WEST SUSSEX COUNTY COUNCIL CONSULTATION

TO:	Arun District Council FAO: Ross Leal
FROM:	Highways, WSCC – Matthew Bartle
DATE:	14 May 2018
LOCATION:	Pound Place Roundstone Lane Angmering BN16 4AL
SUBJECT:	A/51/18/PL 71 bed care home
RECOMMENDATION:	☐ Advice ☐ Modification ☒ More Information ☐ Objection ☐ No Objection ☐ Refusal

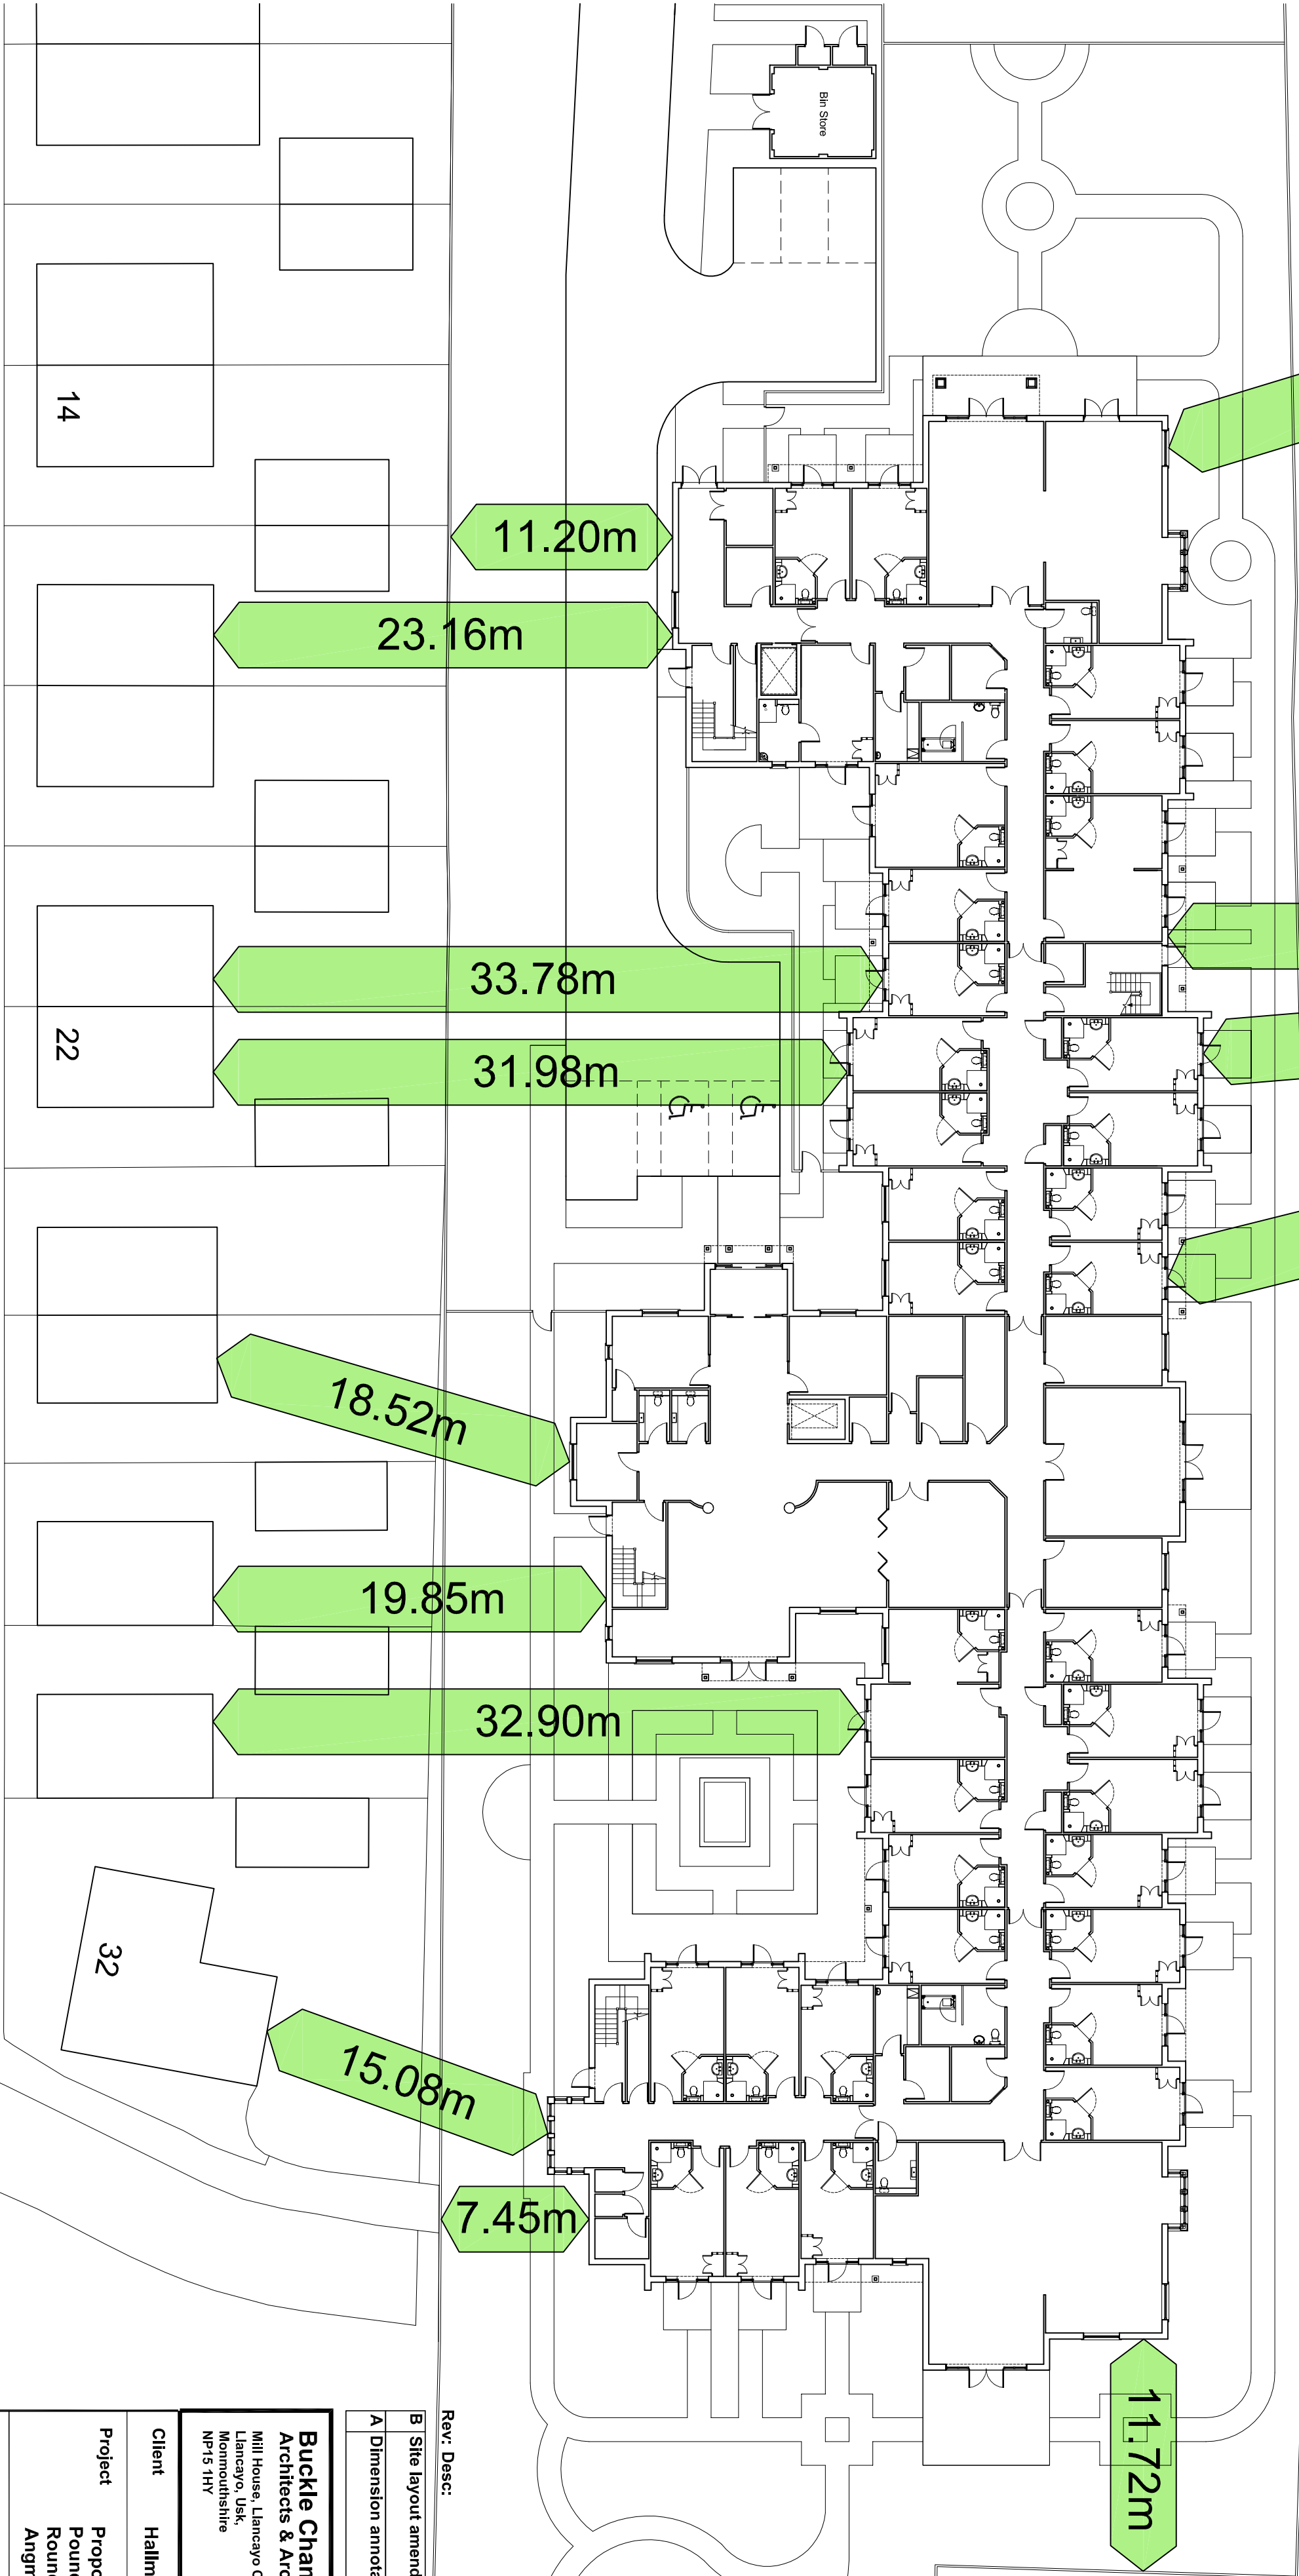
The County Council needs to see a road safety audit and road safety audit response report looking at the site access from Roundstone Lane before commenting further. More details can be seen at:
